# 11 Gibbons Street Redfern

SDRP Design Review Process Summary

**SDRP DESIGN REVIEW PROCESS**  
**SUMMARY OF ITEMS & RESPONSES**

11929  
 Level 3  
 1:100@A1  
 February 2019

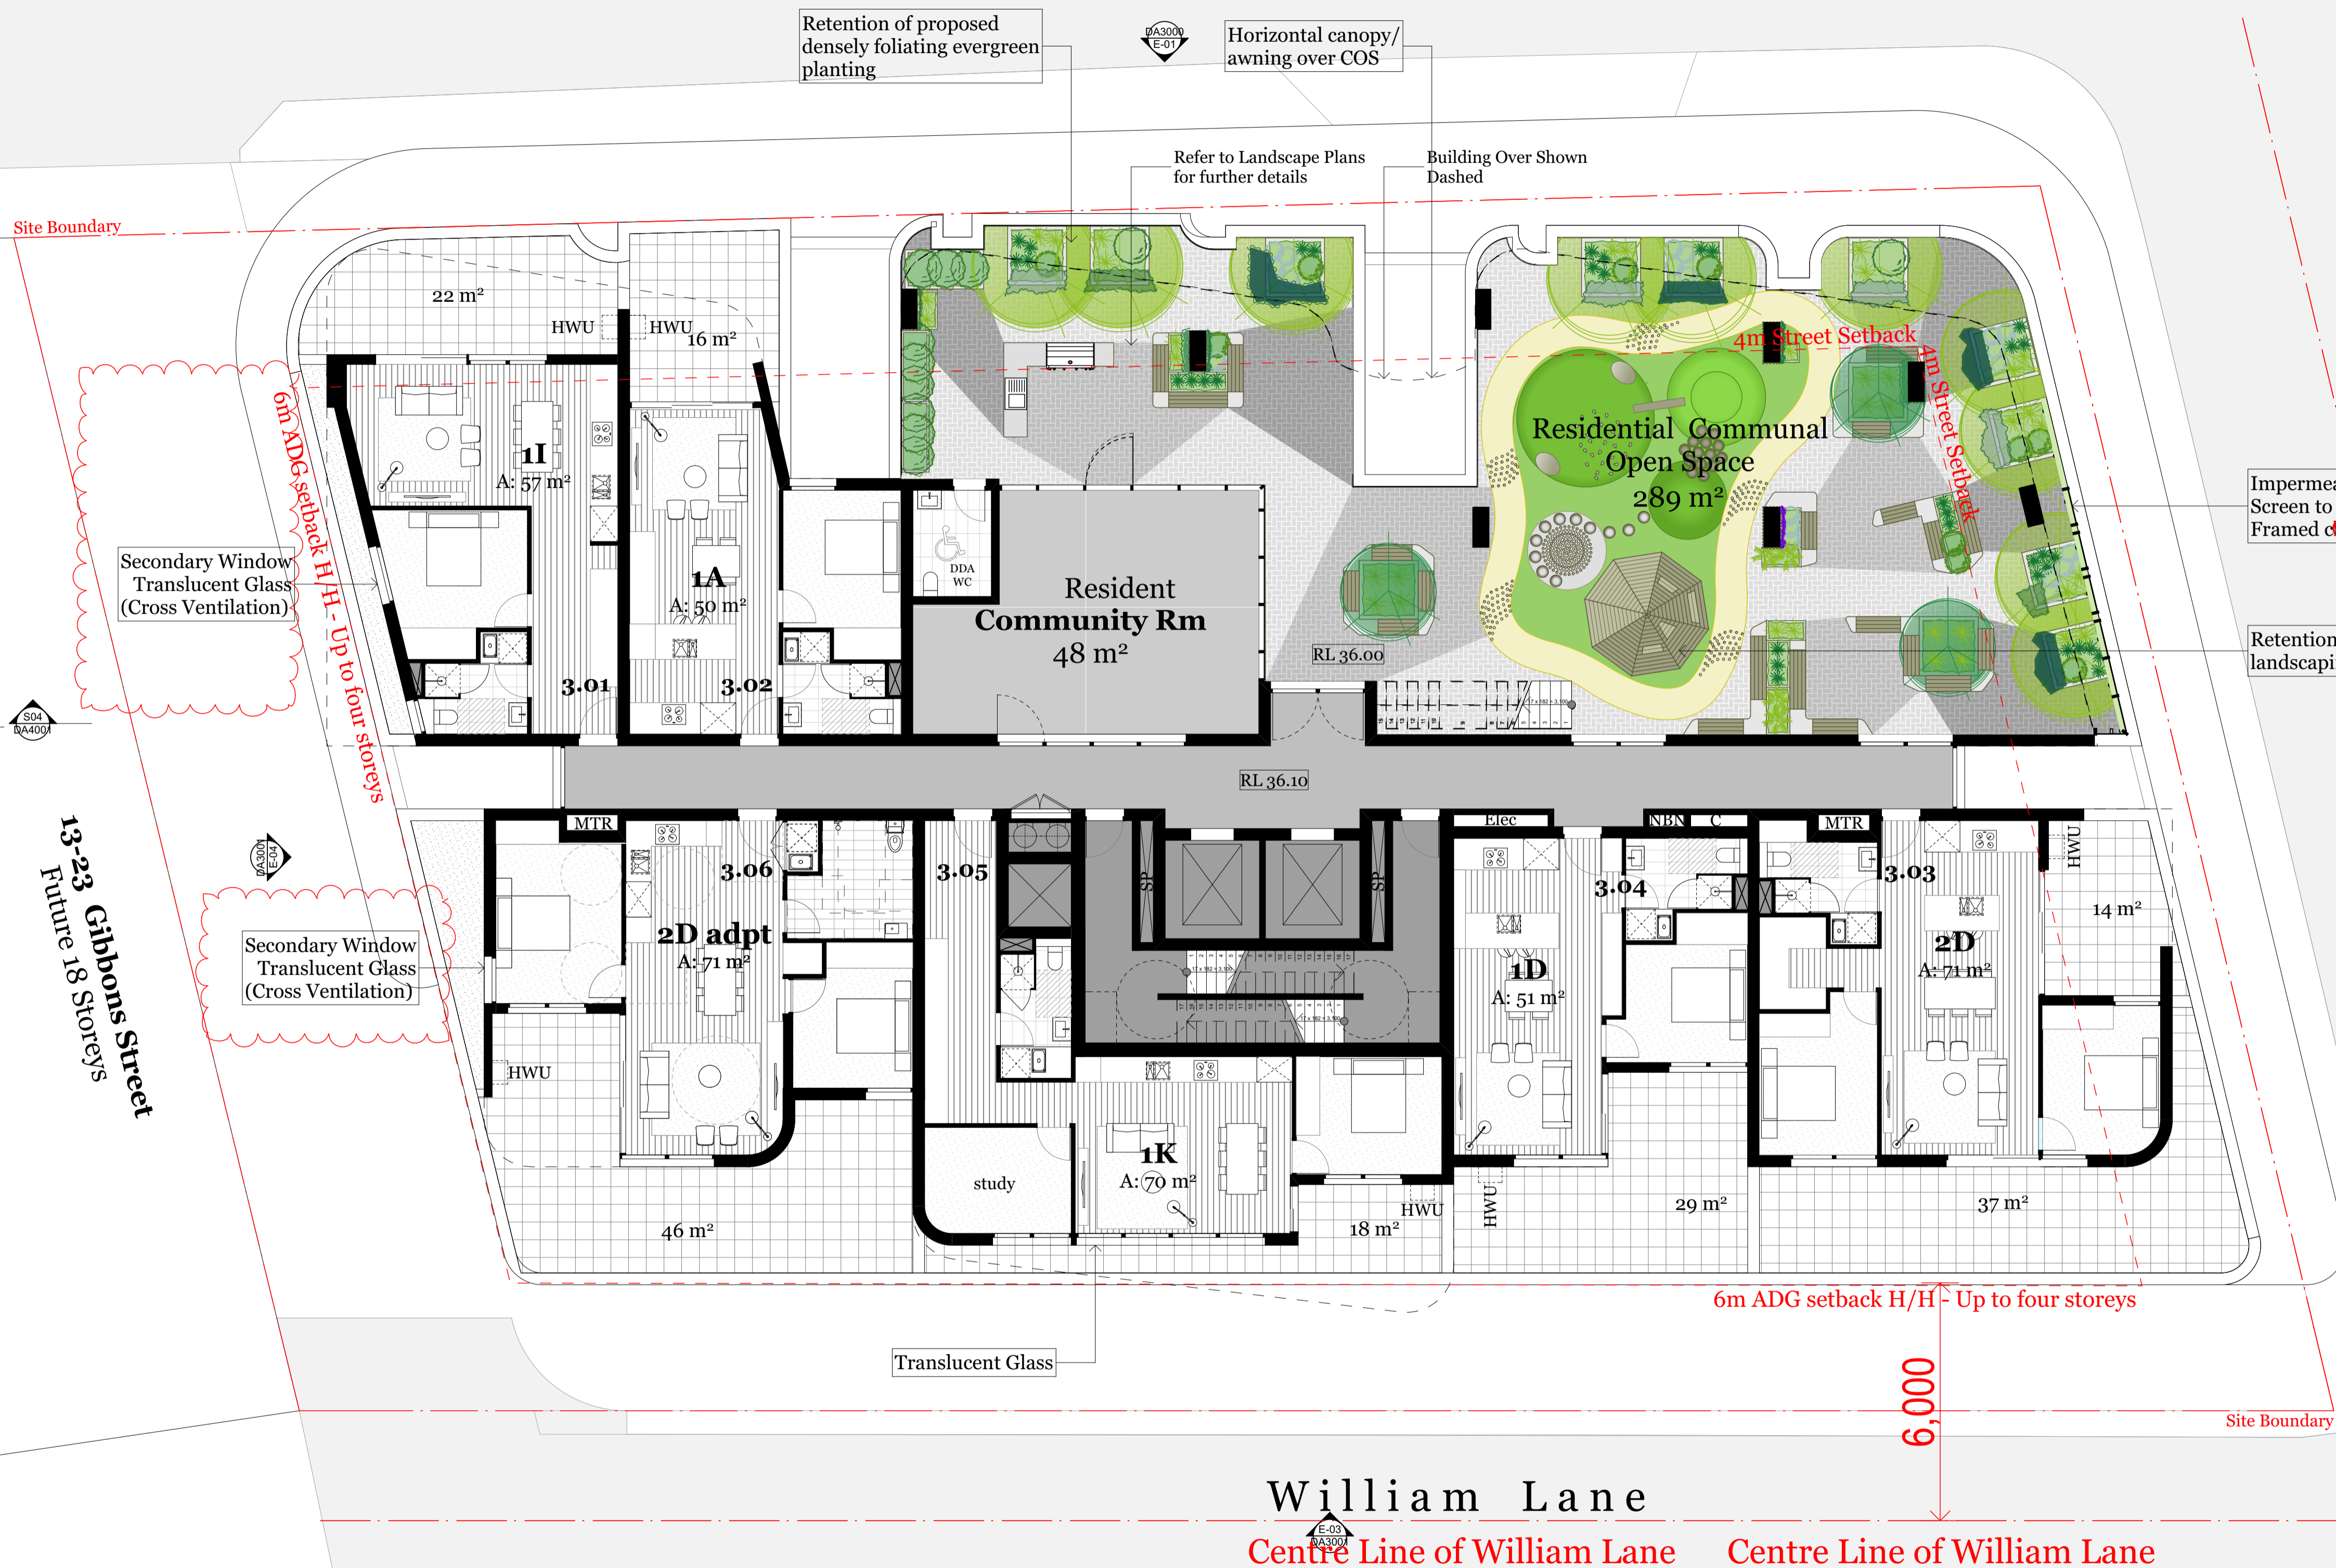
| SDRP Session 1 (16/05/18)  | SDRP Session 2 (14/06/18)  | SDRP Session 3 (08/08/2018)  | SDRP Session 3A (21/08/2018)  | DA Submission |
|--|--|--|---|---------------|
| 1.7 Communal rooms / open spaces for residents that have visual connection with street |  | A generous communal open space and resident's common room is located on level 3. Its location at the lower level provides great visual connection to the street. The smaller communal open space at level 17 will also be visible from the street. |   |               |

| SDRP Session 1 (16/05/18)  | SDRP Session 2 (14/06/18) | SDRP Session 3 (08/08/2018)                                  | SDRP Session 3A (21/08/2018)   | DA Submission   |
|--|---------------------------|--|--|---|
| 2.12 Wind and noise amelioration to COS  |                           |  | From consultation with specialist wind and acoustic consultants, multiple measures have been taken into account. Such as raised balustrade height along all edges, high screen along the northern edge of the podium COS, planted buffer edges and an additional awning to level 5 located in between two tower forms. |   |
